RE: ENGINEER CERTIFICATION FOR ORTH-MEDICS INCORPORATED (M16-D22)
CERTIFICATION STATEMENT DATED 12/9/92.

RE: DRAINAGE PLAN FOR ORTHO-MEDICS, INC.
(M-16/D22) ENGINEER'S STAMP DATED JANUARY 27, 1988

RE: Engineer's Certification for Ortho-Medics
Incorporated (M16-D22)

RE: ENGINEER'S CERTIFICATION FOR ORTHO-MEDICS INCORPORATED (M16-D22)
CERTIFICATION STATEMENT DATED 10/19/92.

GRADING & DRAINAGE PLAN  
ORTHO-MEDICS, INC.

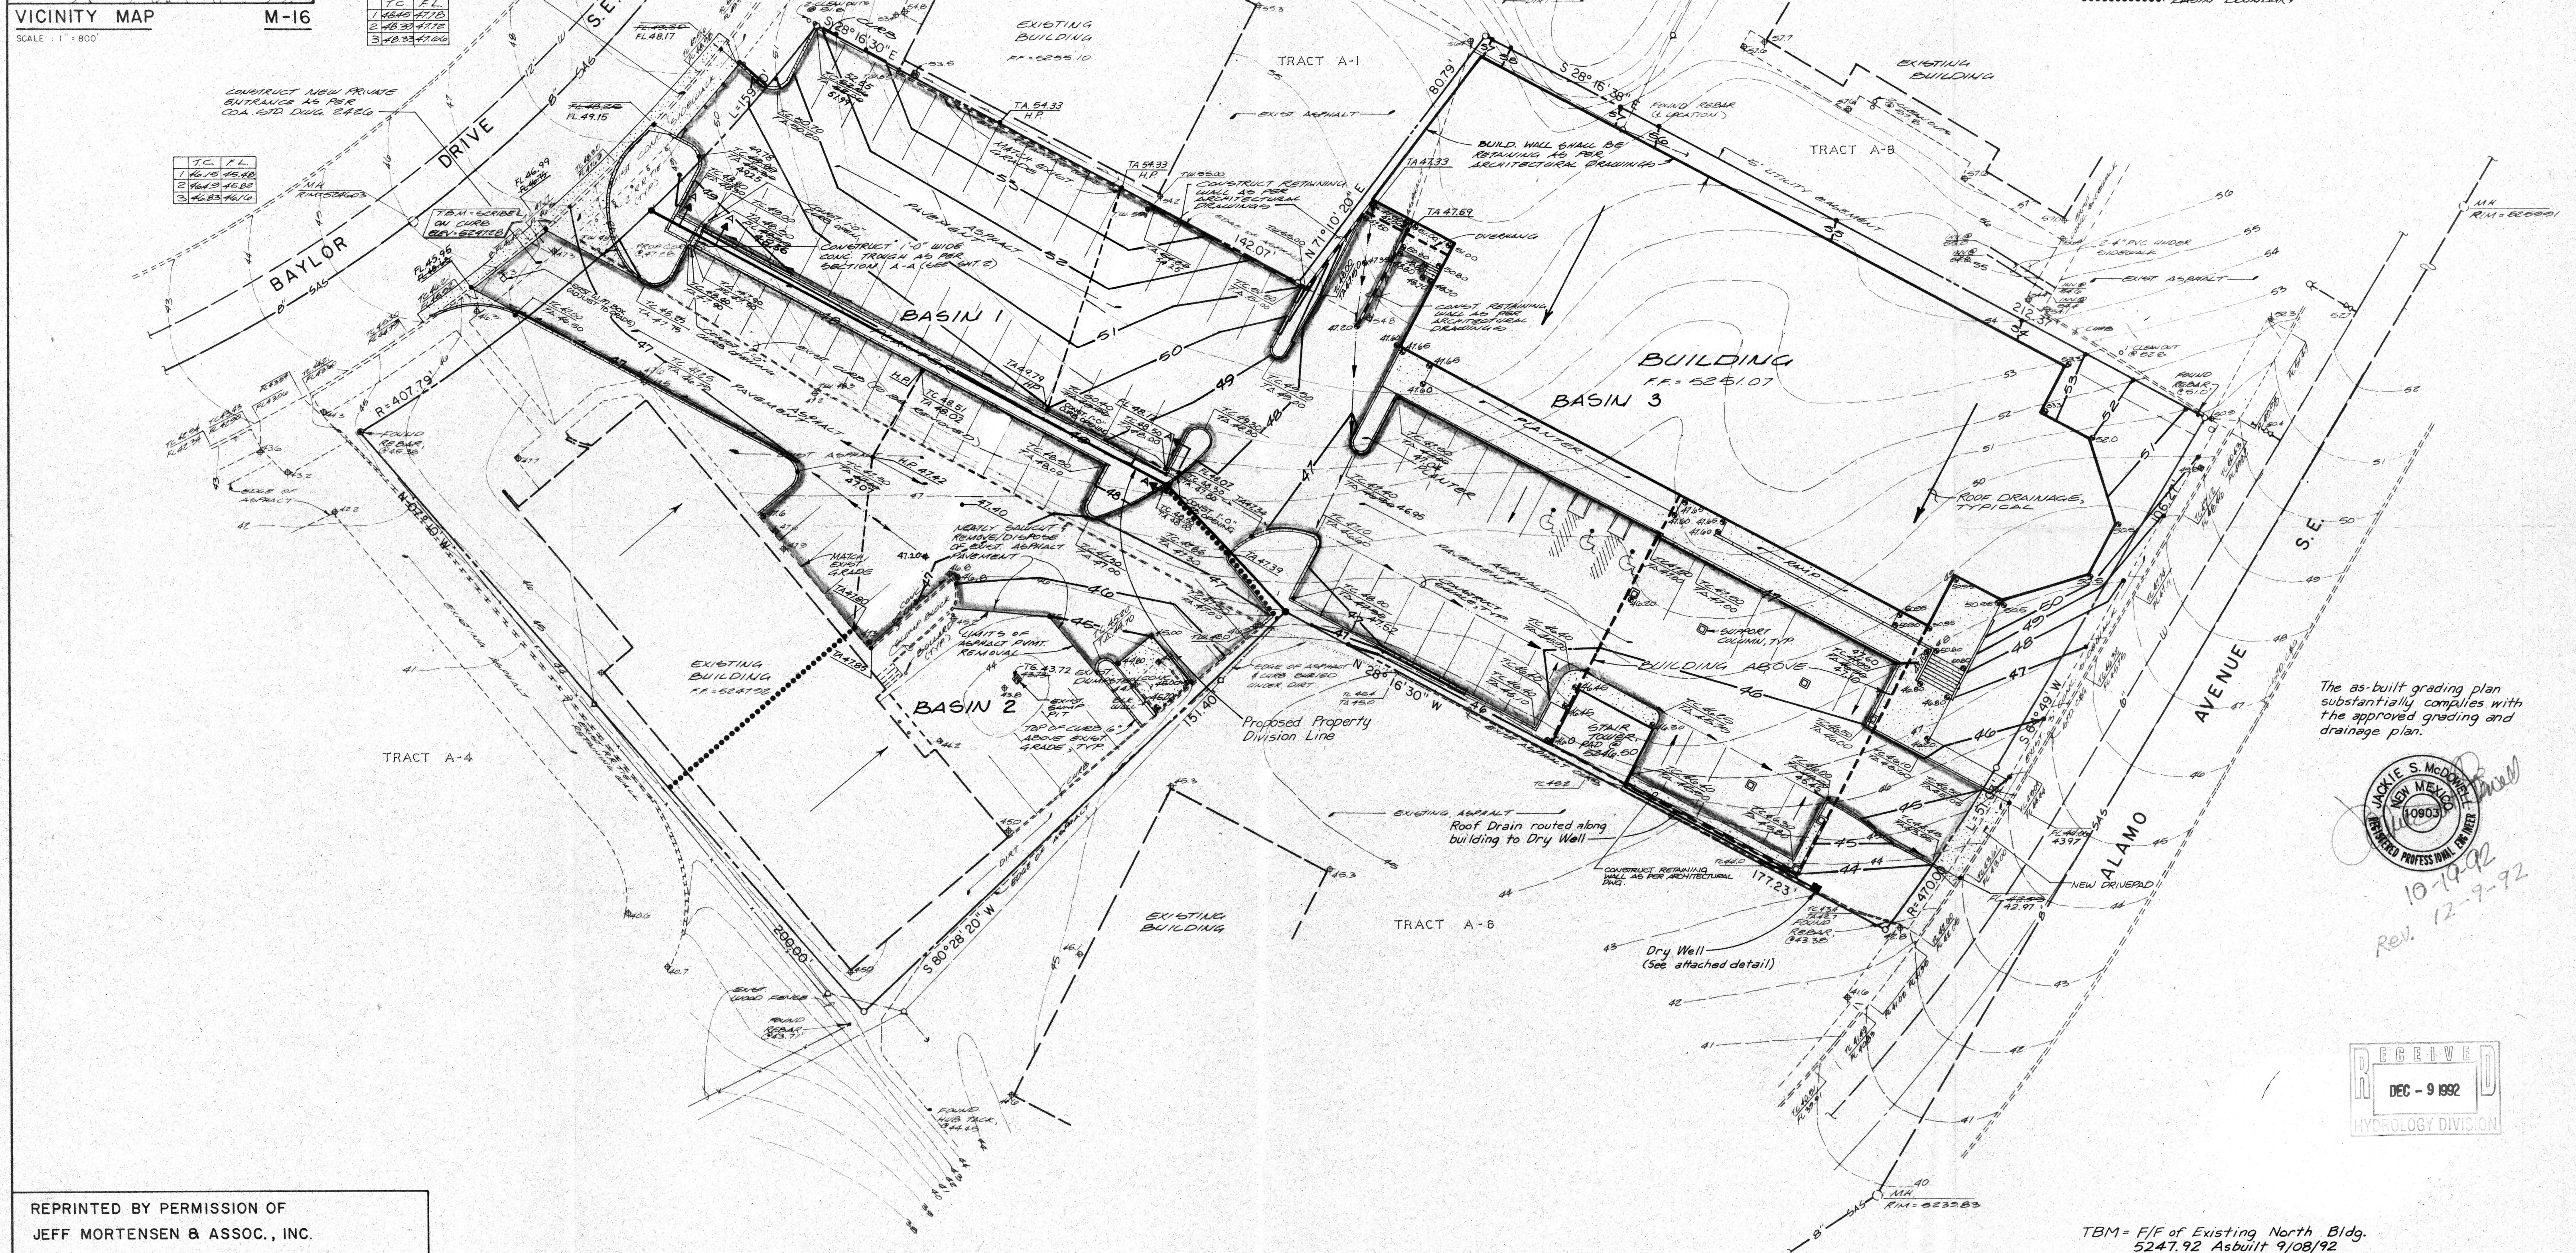
Based on the information provided on your December 9, 1992 submittal Certification for the above referenced site is acceptable for final plat approval. The final plat will include a blanket easement for run-off from Basin 1 onto Basin 2.

GRADING & DRAINAGE PLAN  
ORTHO-MEDICS, INC.

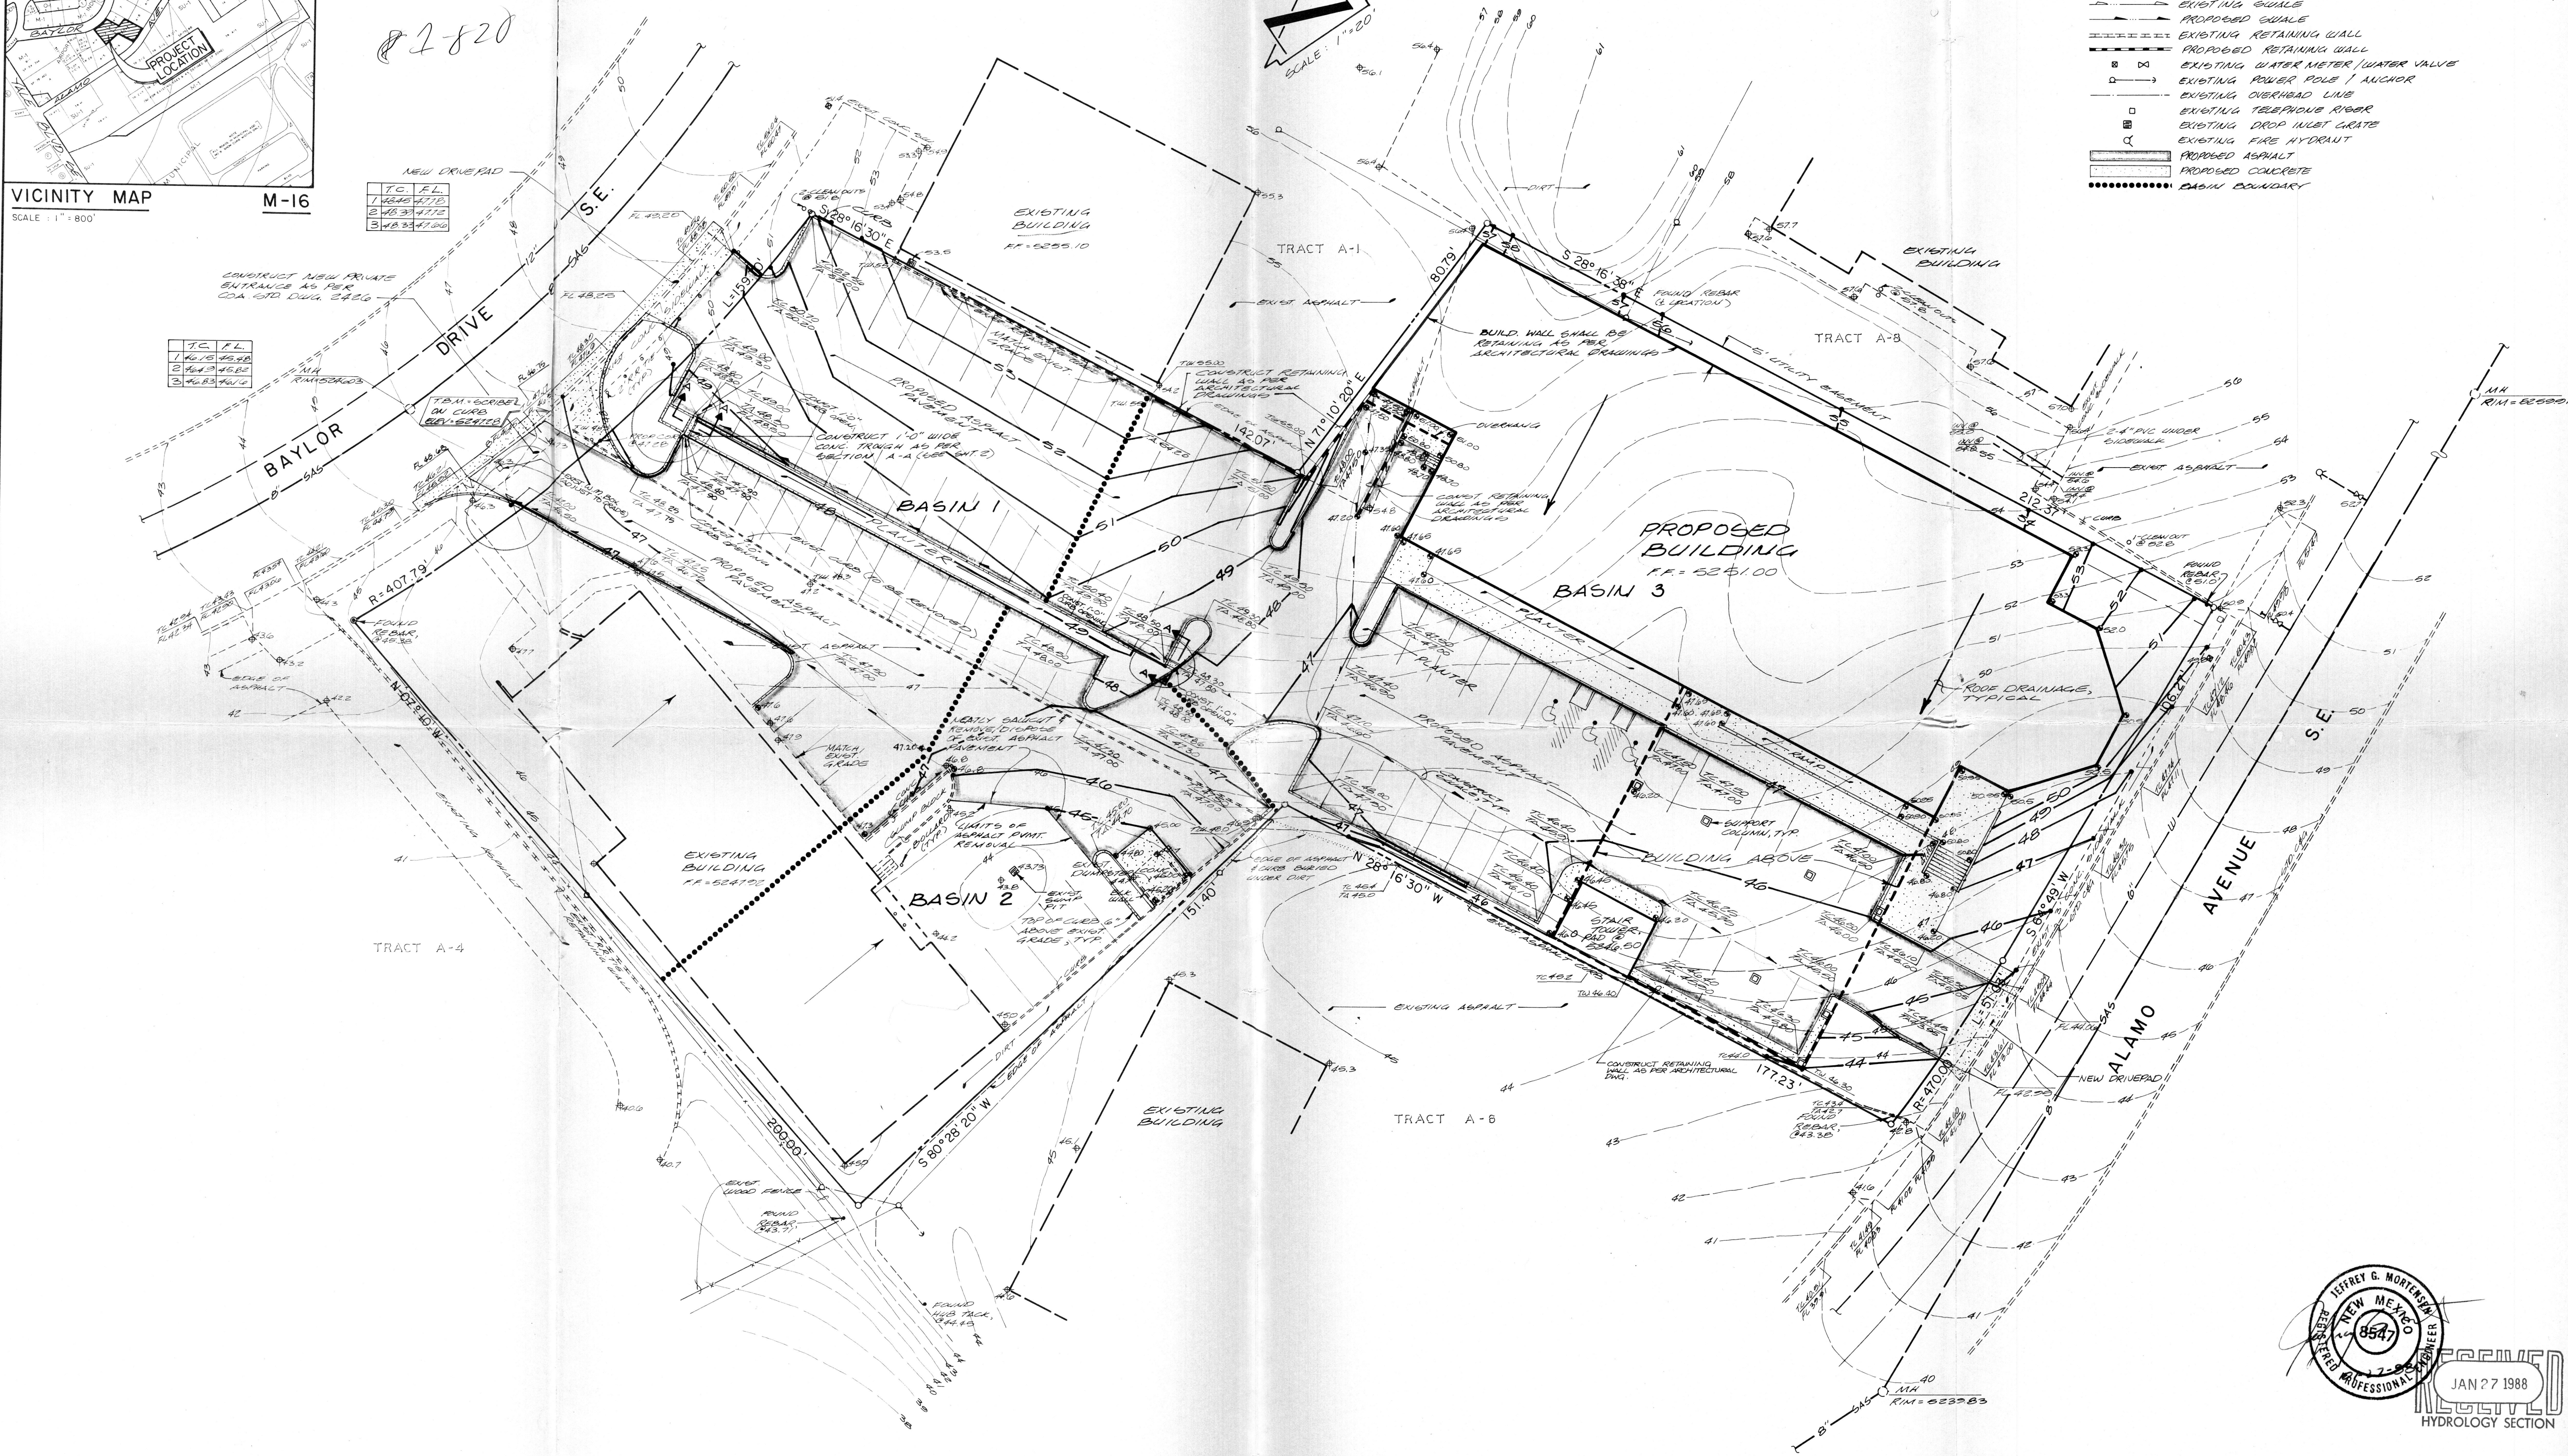
The proposed subdivision will require an
updated as-built drainage plan. The
updated plan should identify any discrepancies
with the approved plan dated 8-27-88
prepared by JEFF Morrison. Identify the
proposed private drainage easement that
will need to be granted with the plat
action above.
